**SUBJECT: Grandview Reserve Filing No. 1**  
**SF\_Final Plat (SF-22-XXX) – Letter of Intent**  
**SF-23-011**

This Letter of Intent (LOI) is being submitted as part of the Final Plat Review (SF-22-XXX) application for Grandview Reserve Filing No. 1 on behalf of 4 Site Investments, LLC.

DRAWN BY JWT
CHECKED BY ERF

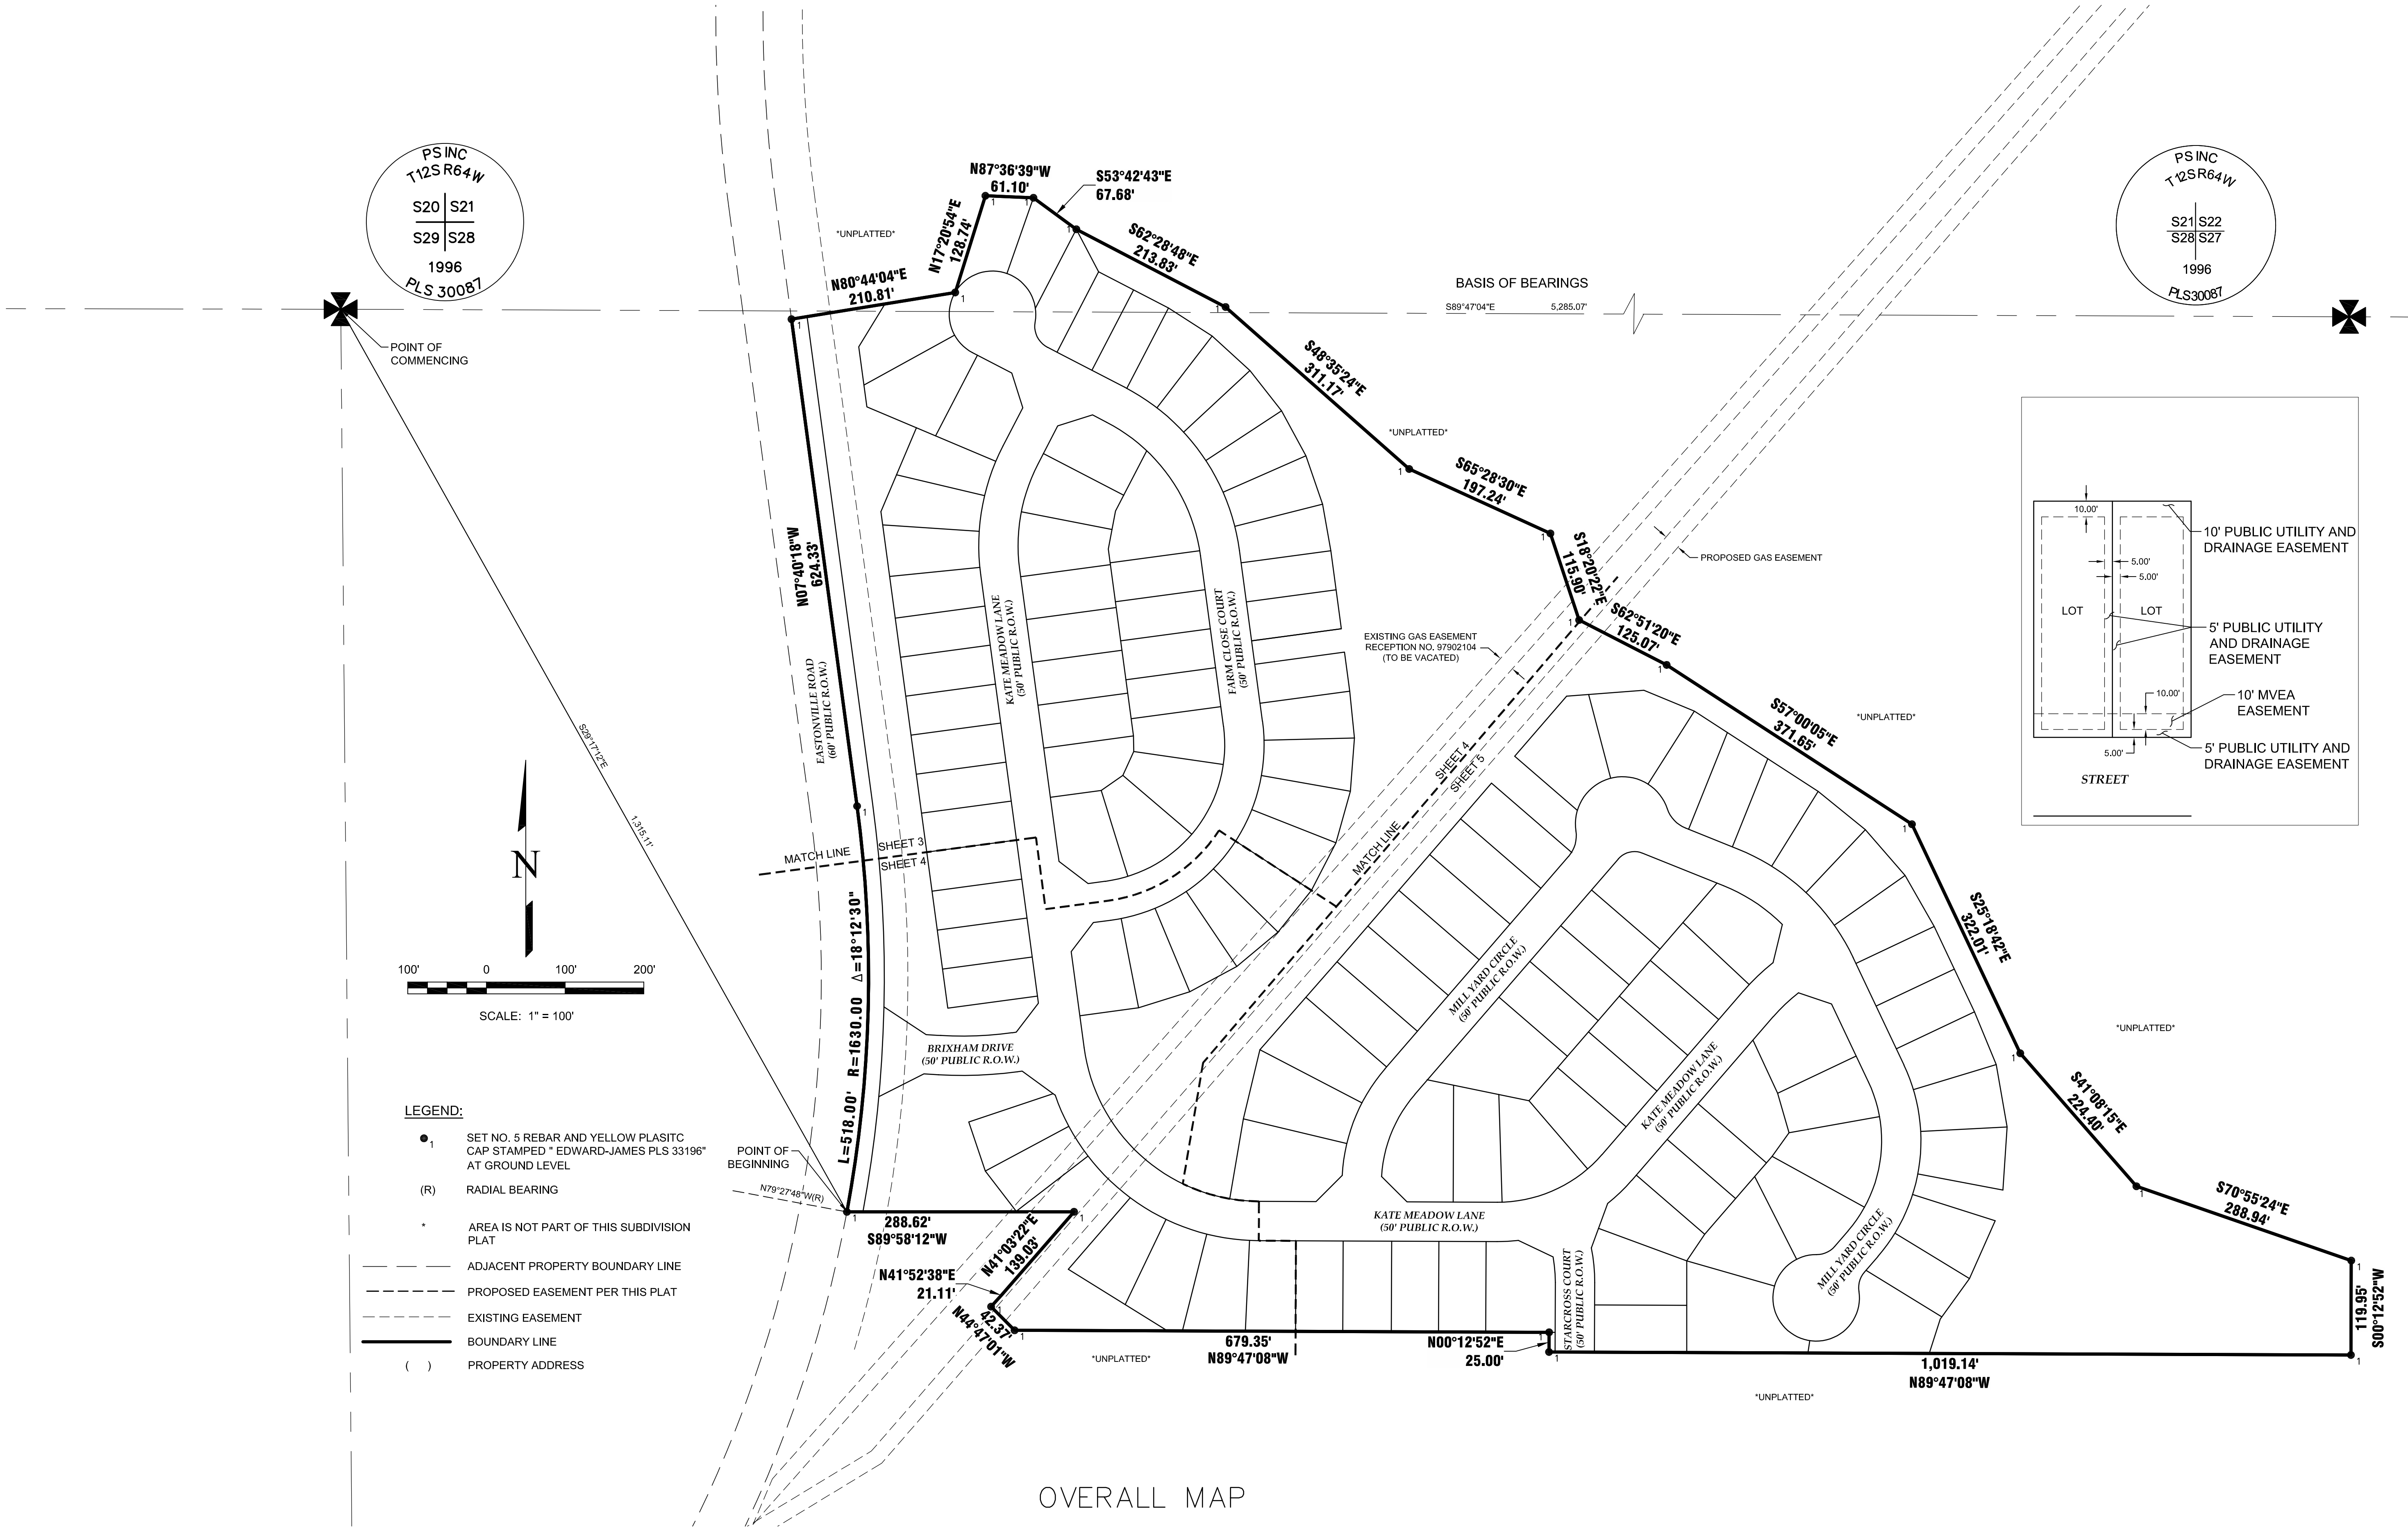
now is the time; this is the last step to entitling lots for sale; depict a plat note with no basements for certain lots
